Application No: EP/48/21/HH
Site Address: 2 Bay Tree Garden East Preston BN16 1JG
Description of works: Erection of single storey rear extension and rear dormer following the demolition of existing garage and workshop.

Thank you for your internet representation made on 4th June 2021 which has been recorded as an objection with the comments as follows:

First Floor Plan

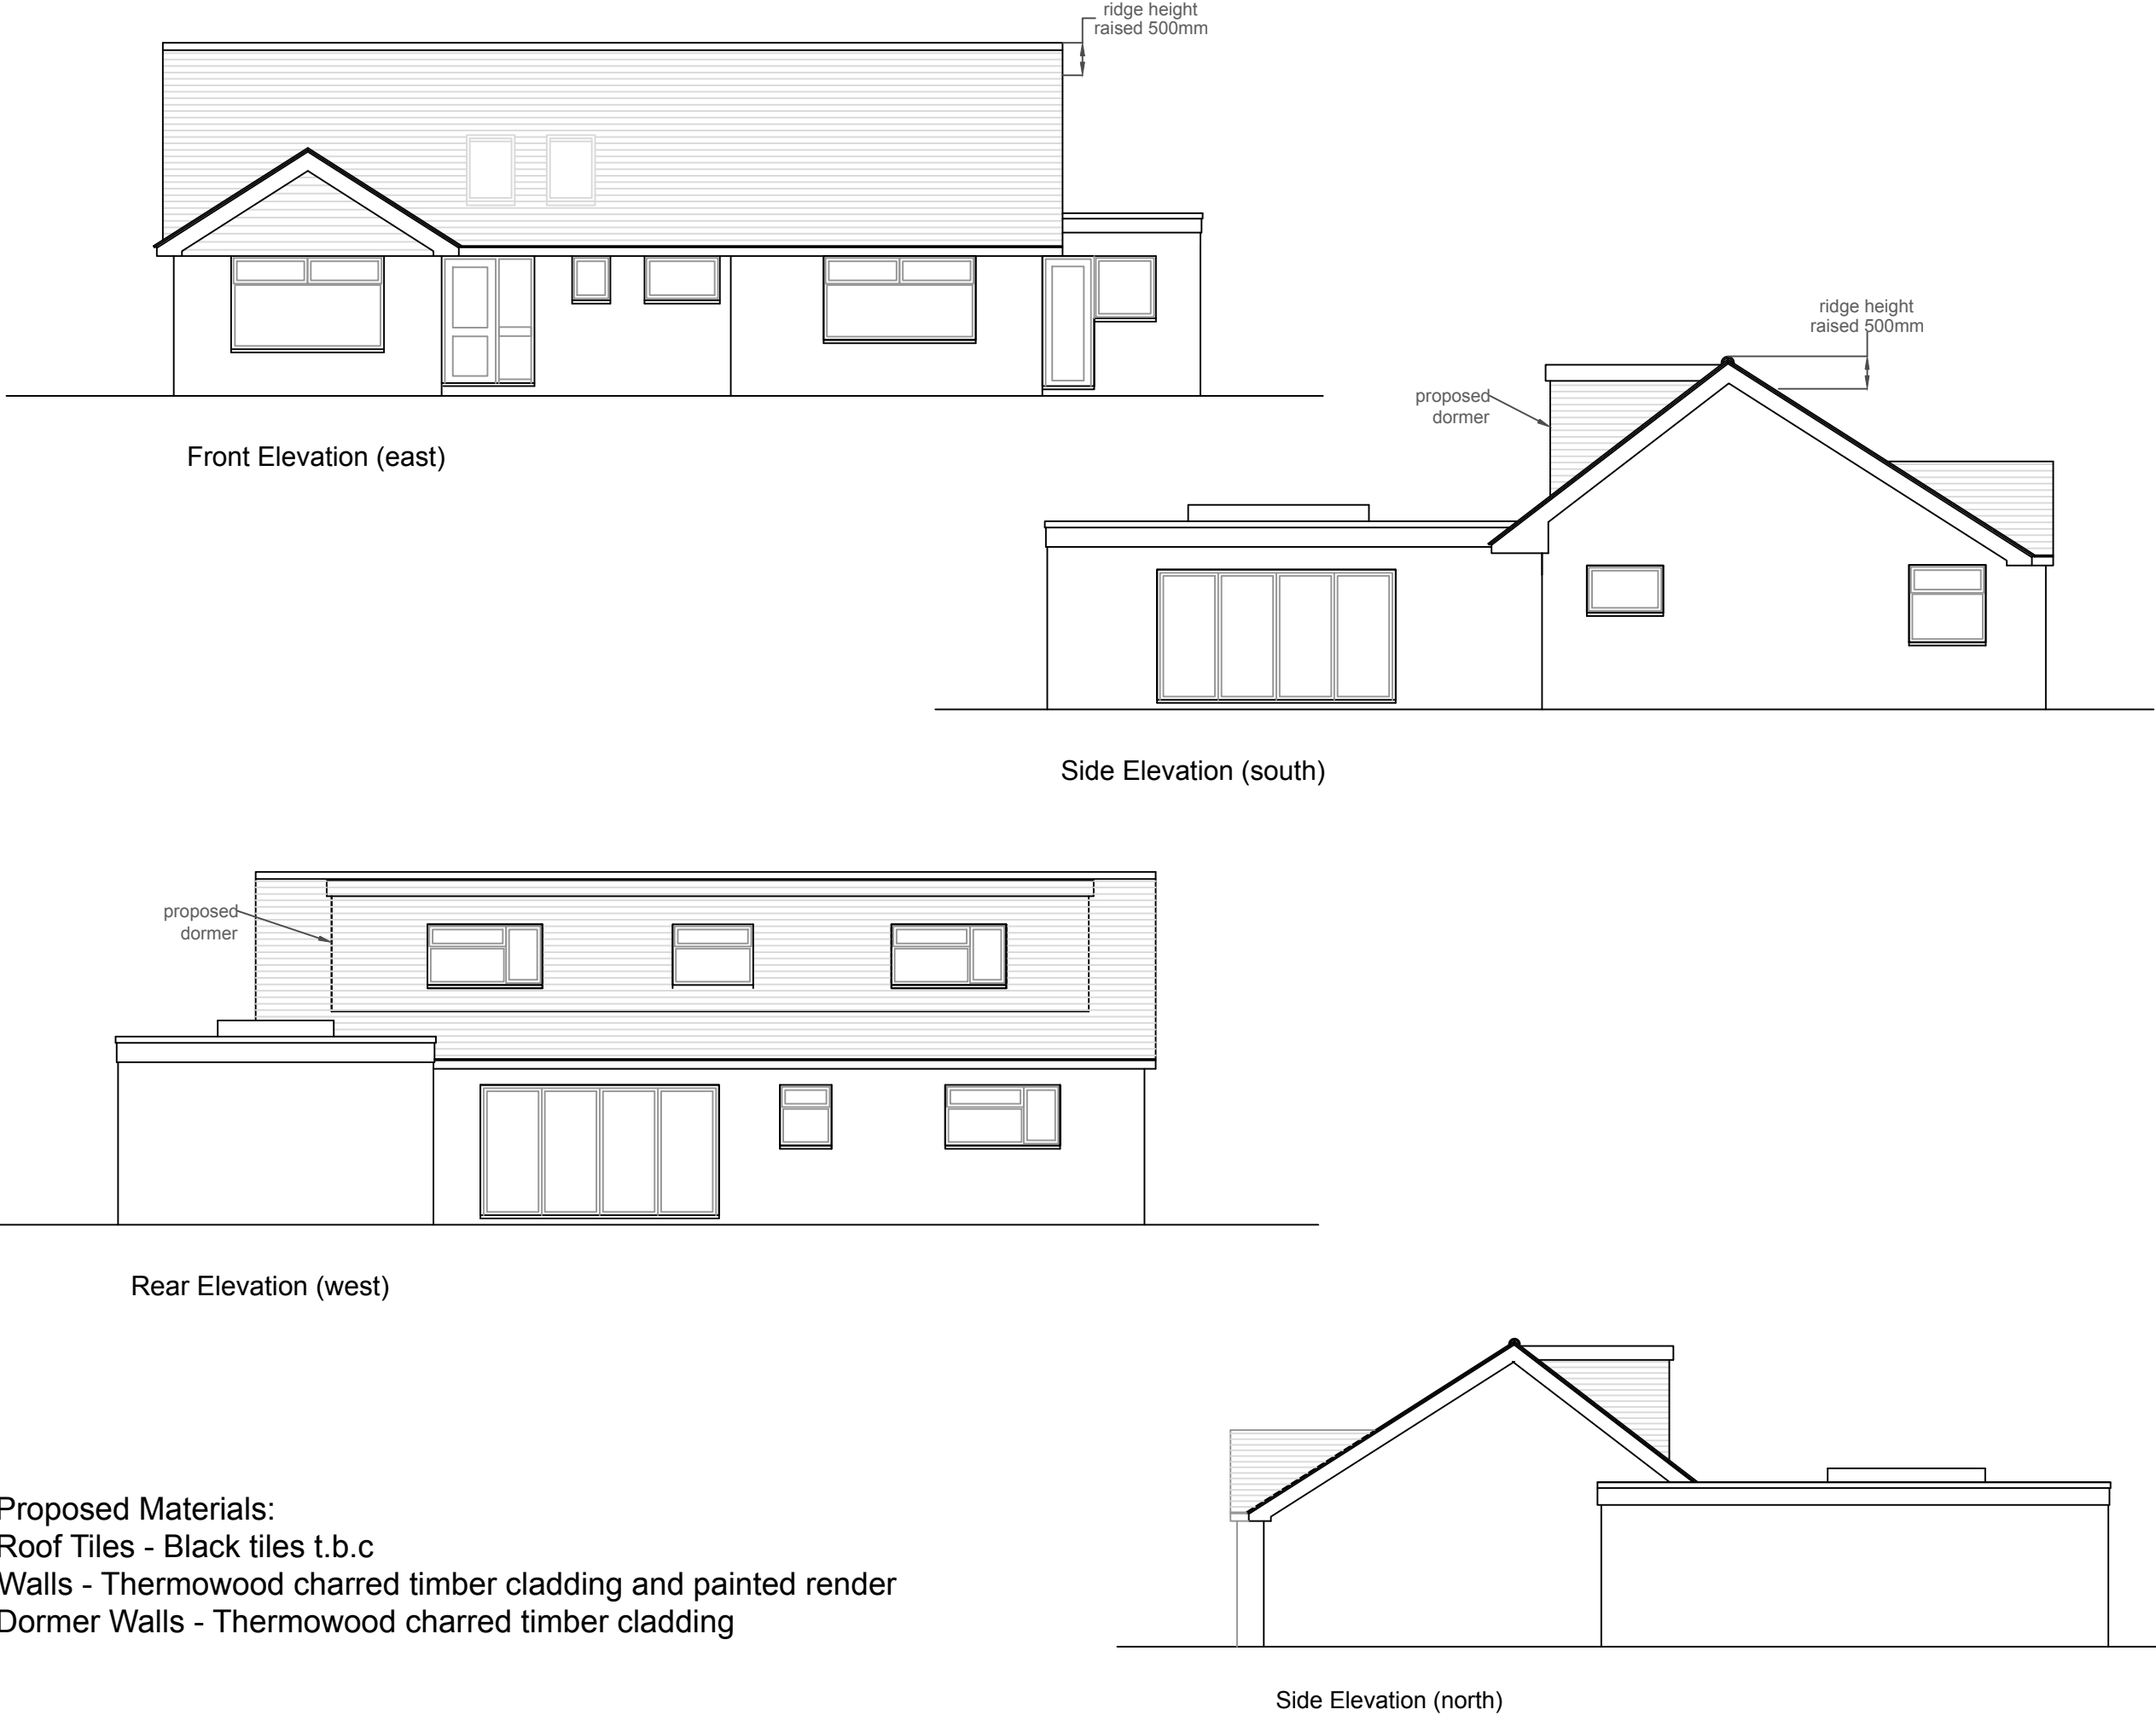
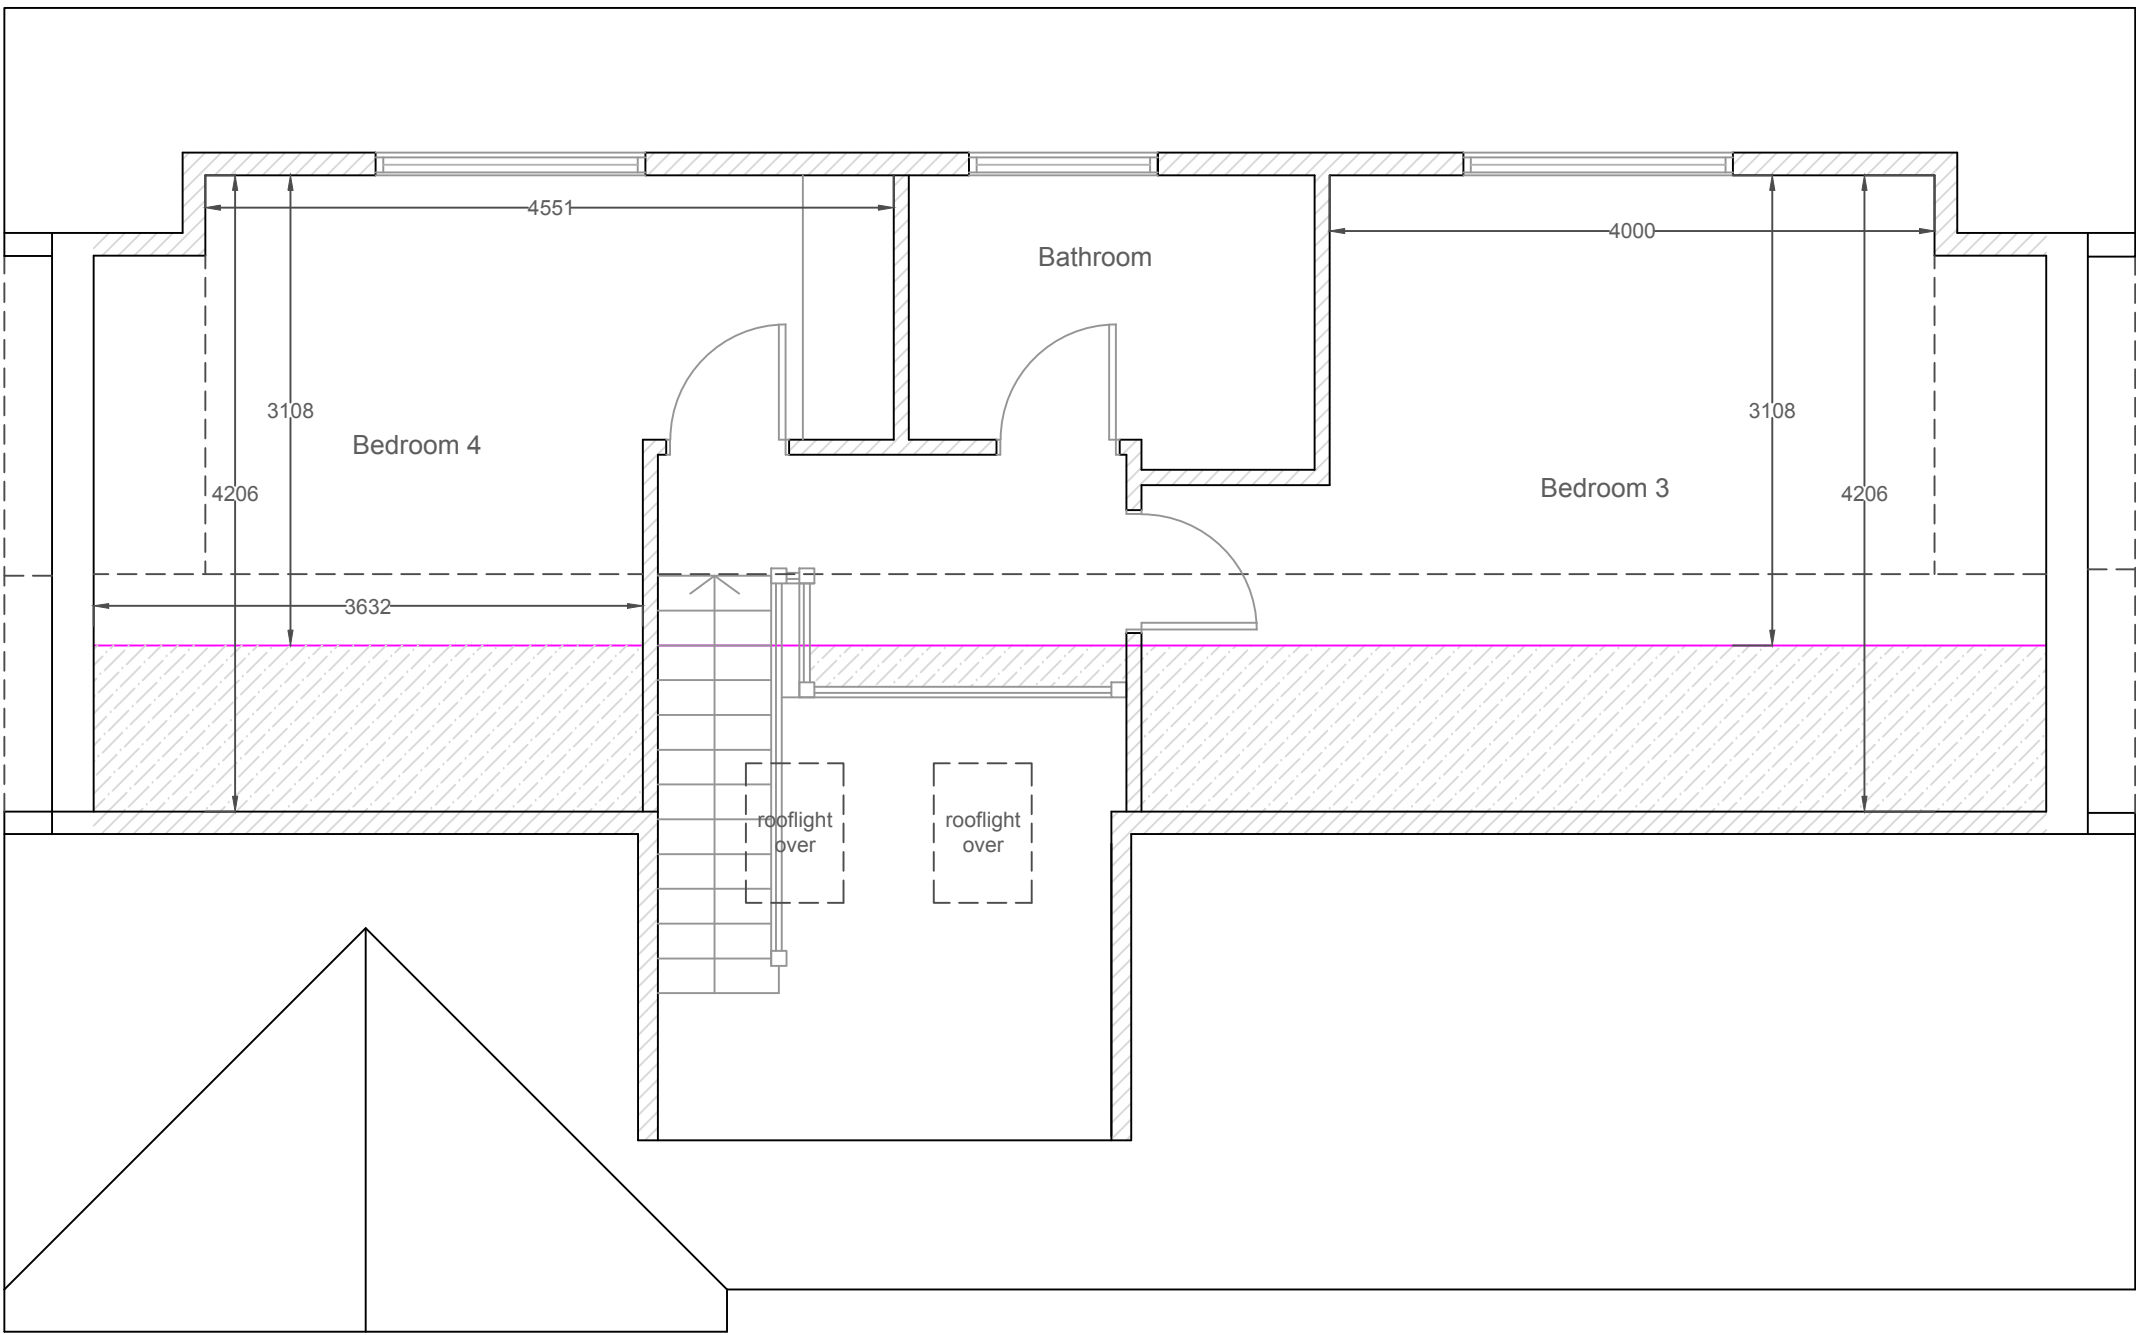
Currently the building is a one storey bungalow. The proposal is to carry out an extensive alteration to the layout of the ground floor accommodation to which we have no objection; in addition to constructing a staircase leading to 3 additional rooms. There will also be the formation of 3 large dormer windows to the rear, facing the rear of our property.

Whilst we will be unaffected by the internal ground floor alterations, the first-floor extension will have a severe detrimental effect on us and our property. The three additional windows will directly overlook our garden and into our house resulting in a complete loss of privacy as we are currently not overlooked from the east. The rear of our house has large bi-folding doors across 2/3 of the width of the house, plus a large kitchen window, which currently are not overlooked. The proposed application will afford a view from the dormer windows directly into our lounge.

- Hitherto we were not overlooked. In addition, the visual impact of the extension is out of keeping with surrounding properties. The first-floor extension which spans the entire length of the roof will be overbearing
- The proposed dormer extension will substantially intrude on our privacy, directly overlooking our garden and into our property
- The proposed materials and construction are out of keeping with the neighbouring properties to the rear of 2 Bay Tree Garden.
- The proposals are, we believe, contrary to policies within the Arun Local Plan and the East Preston

We ask Arun District Council to consider refusing Planning Permission for this proposal as it stands. Should Planning Permission be granted, we ask Arun District Council to consider a condition ensuring the windows in the proposed dormer are all glazed with opaque glass and have limited opening ability, thus protecting our privacy..
